**From:** [REDACTED]  
**To:** [A303 Stonehenge](#)  
**Subject:** Planned closures of byways near Stonehenge  
**Date:** 04 July 2019 18:01:36

EXISTING A303 STOPPED UP, NO CHANGE TO BYWAY AMES 12

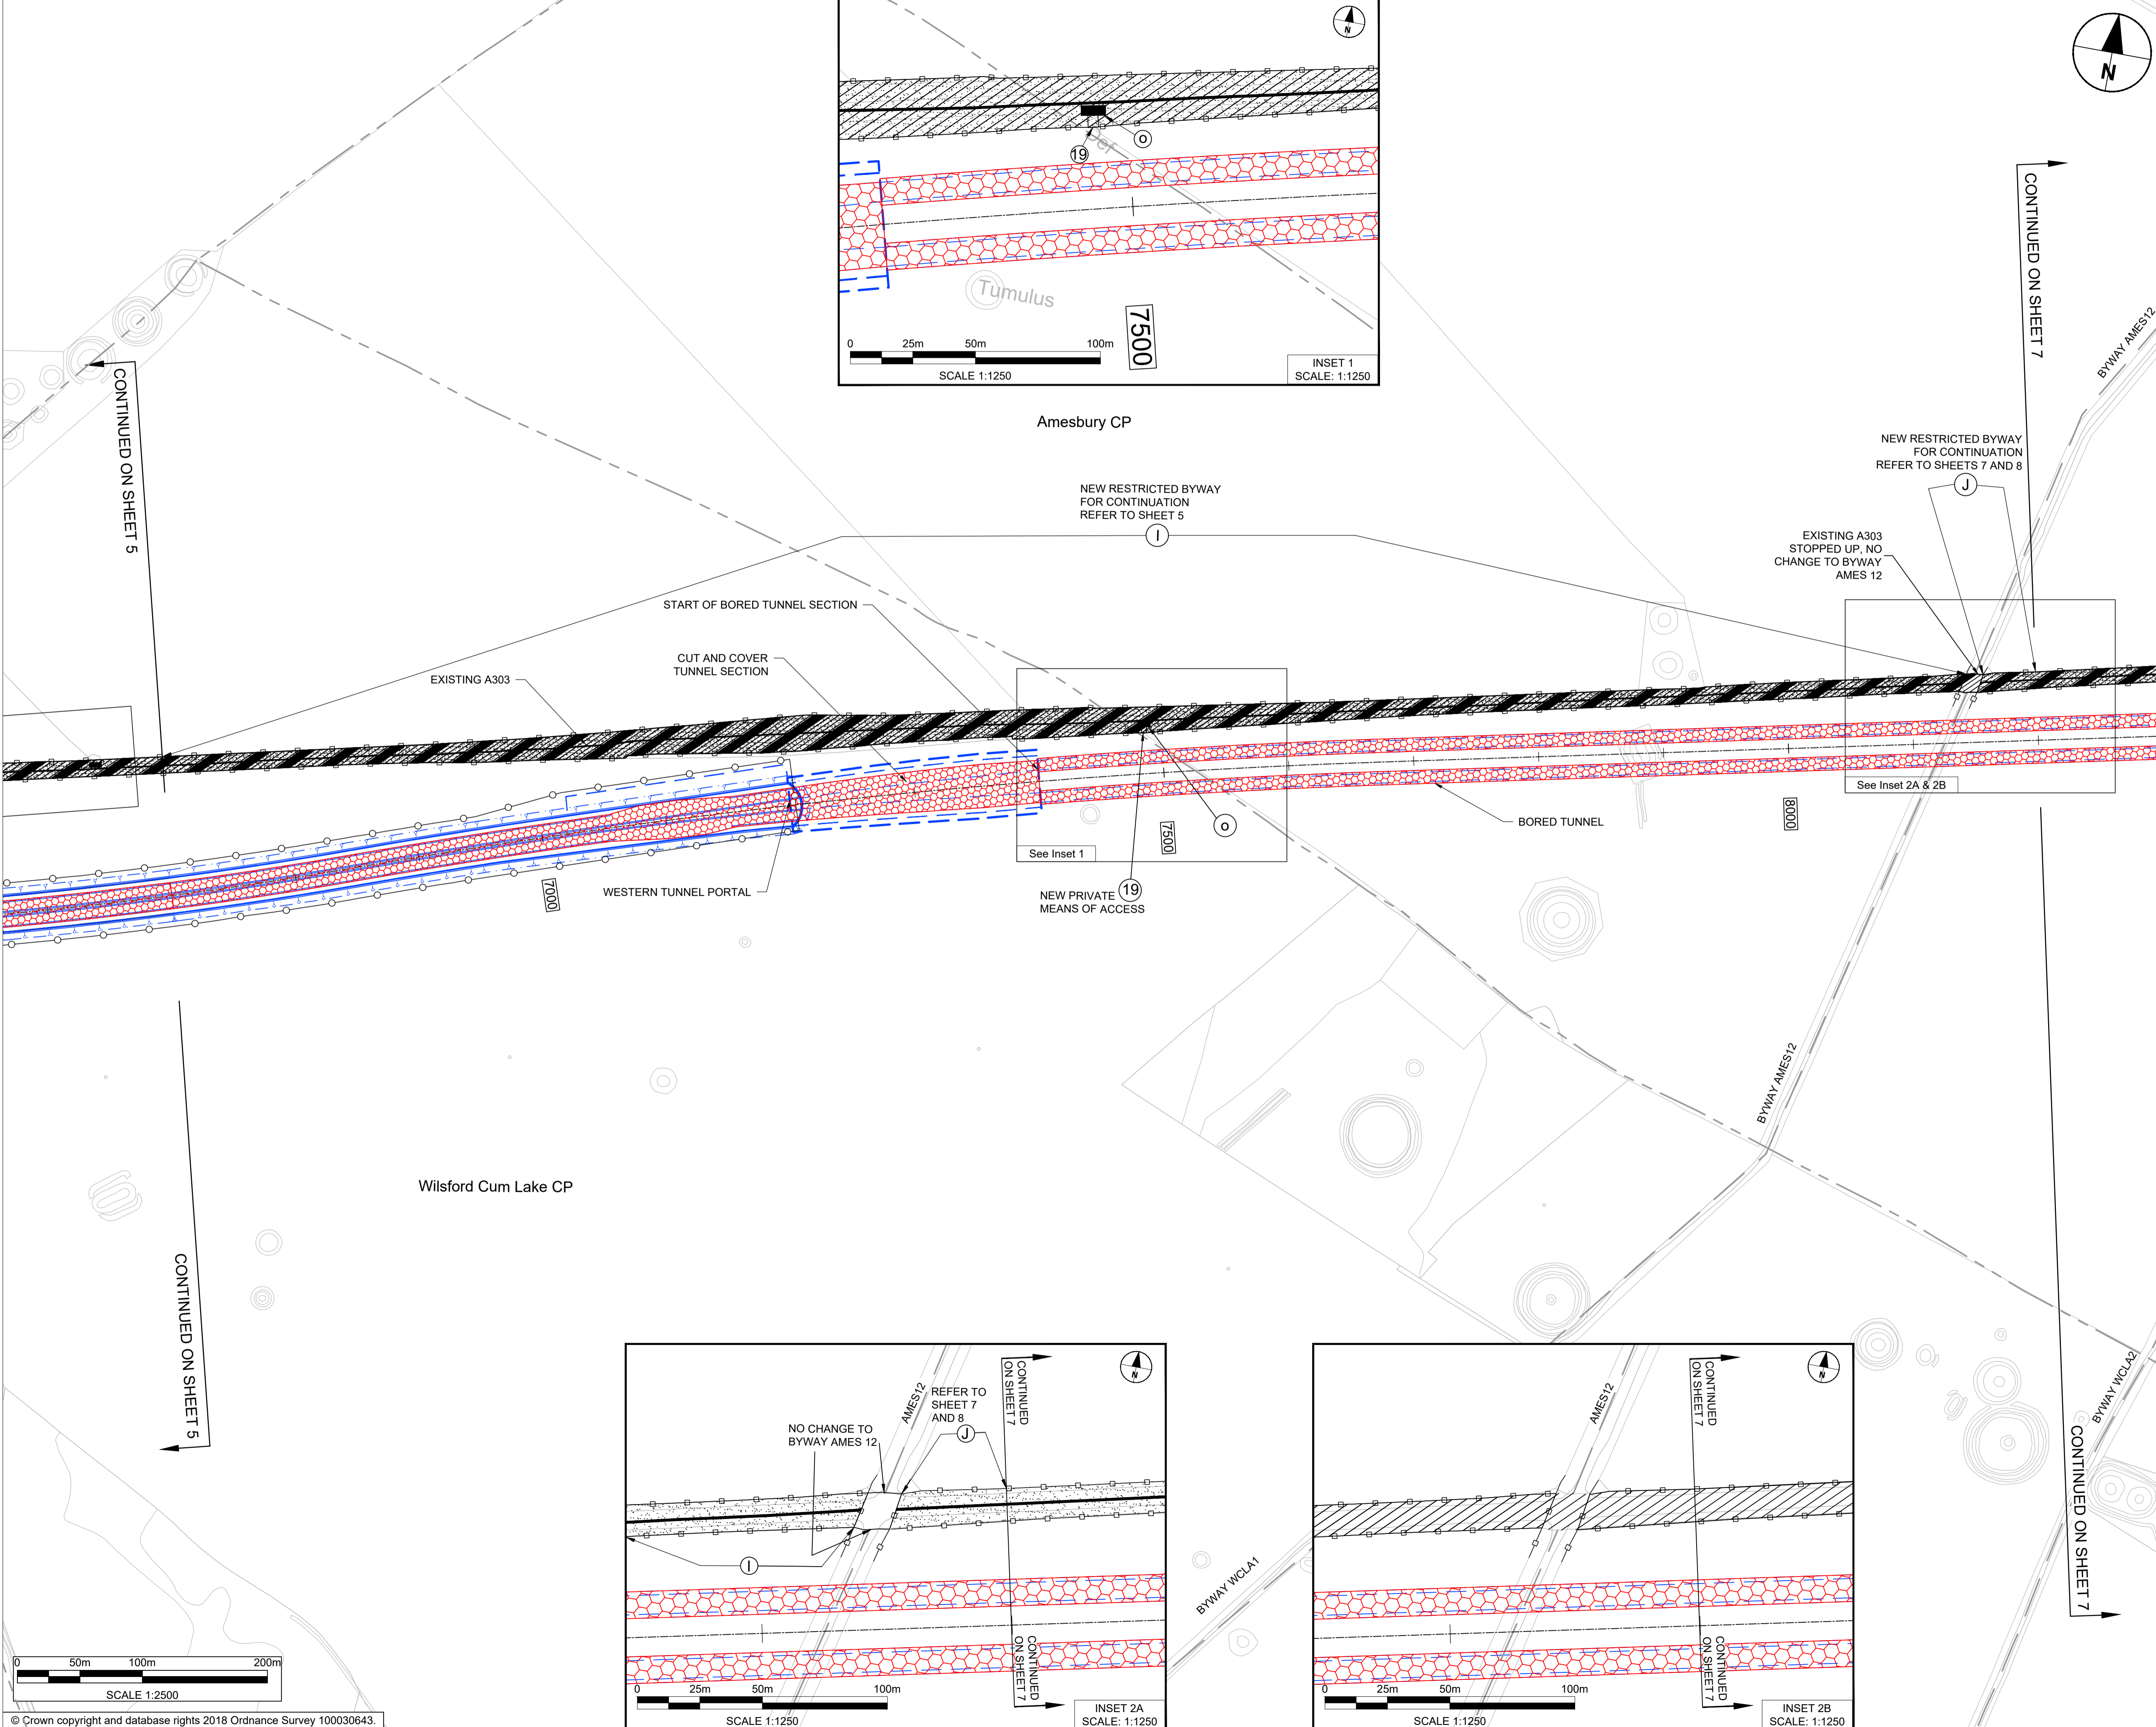
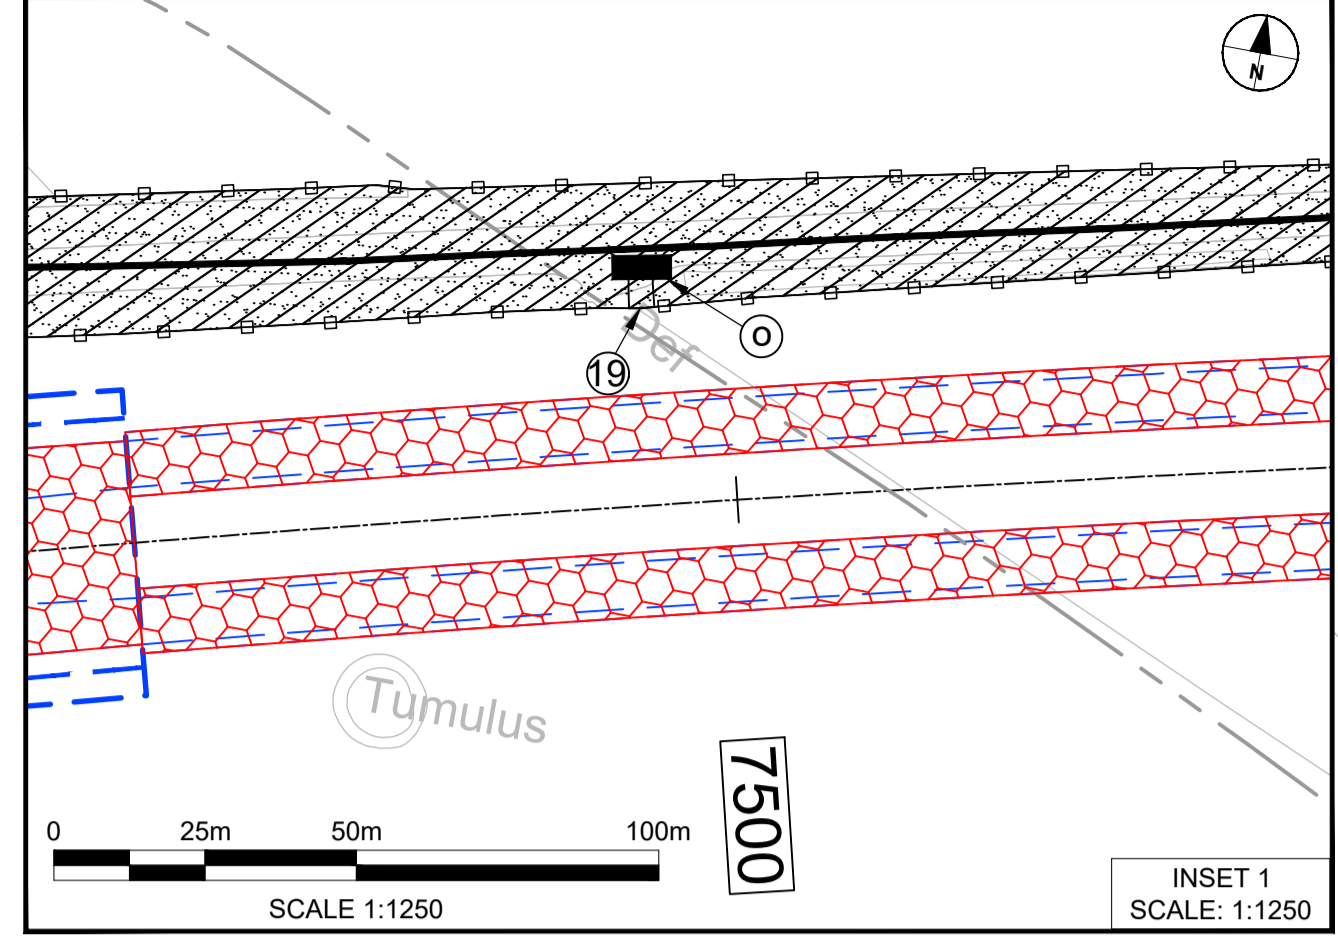
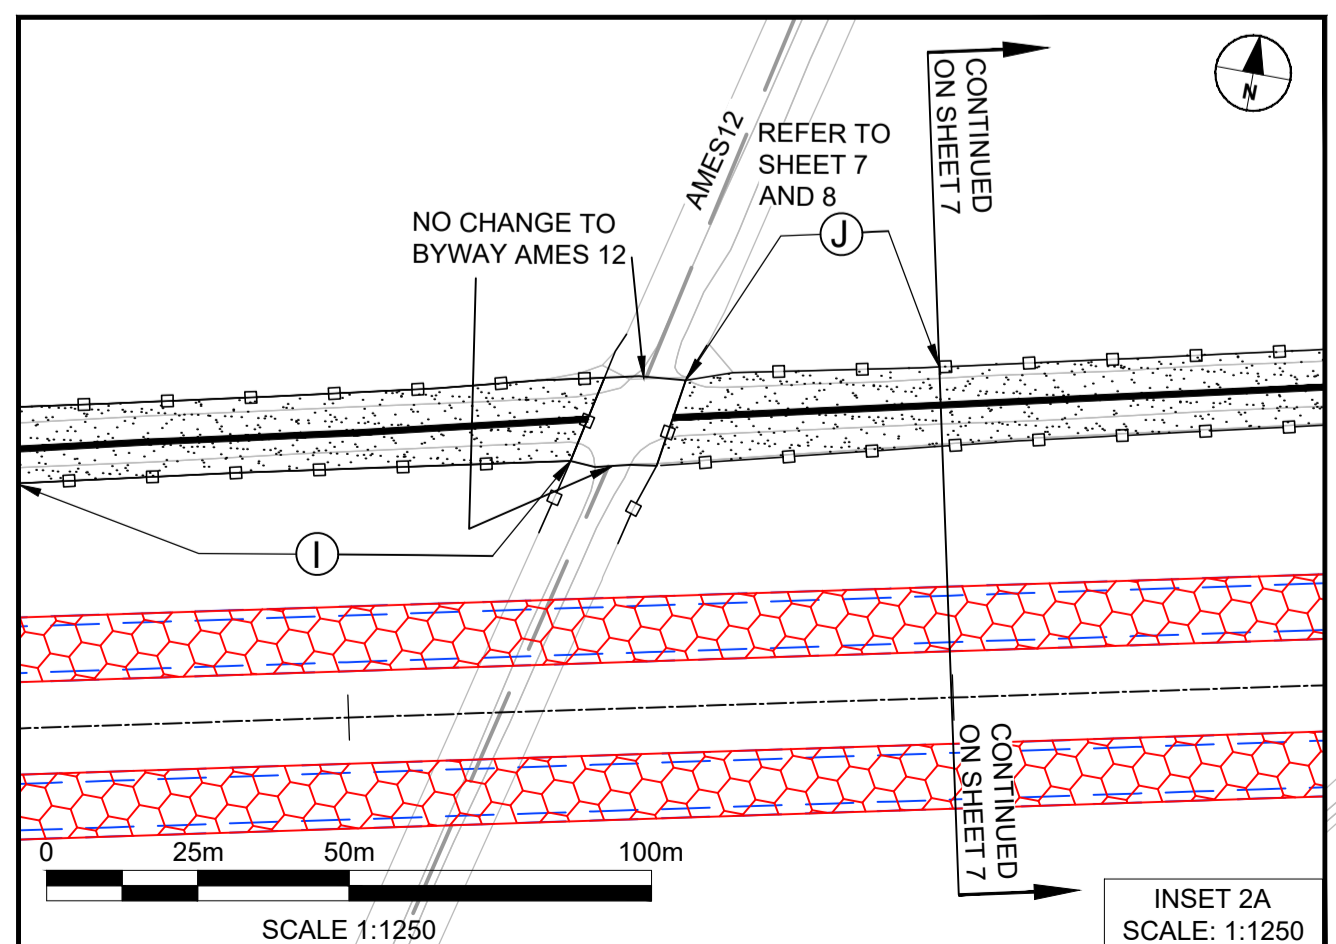
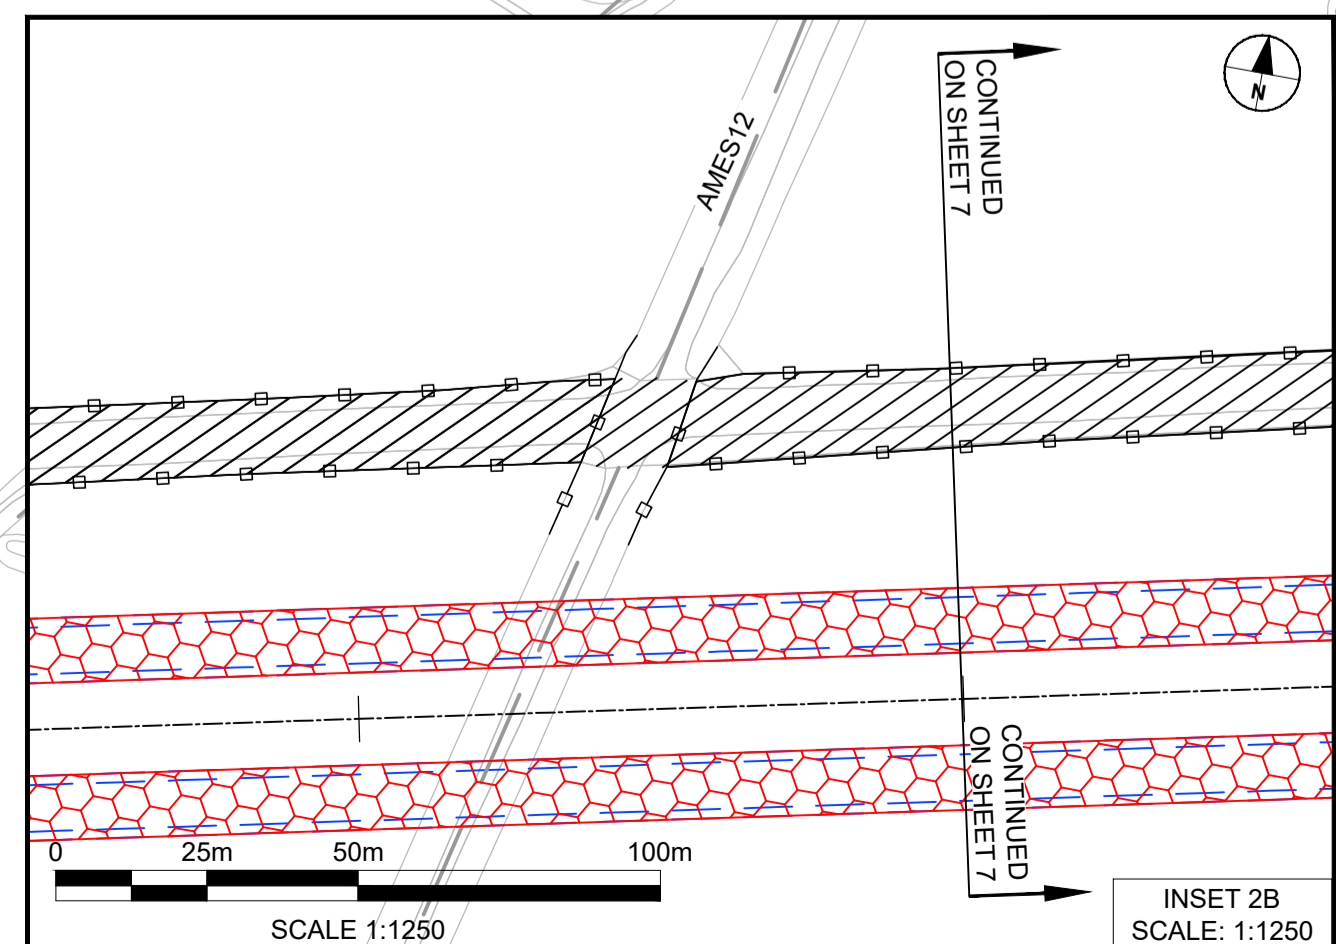
If the planned byways closures are due to the planned works on the A303. Would it not be possible to join the existing byways with the newly formed restricted byway that would be the old route of the A303.

Would that not solve the issue of byway 11 becoming a cul-de-sac.
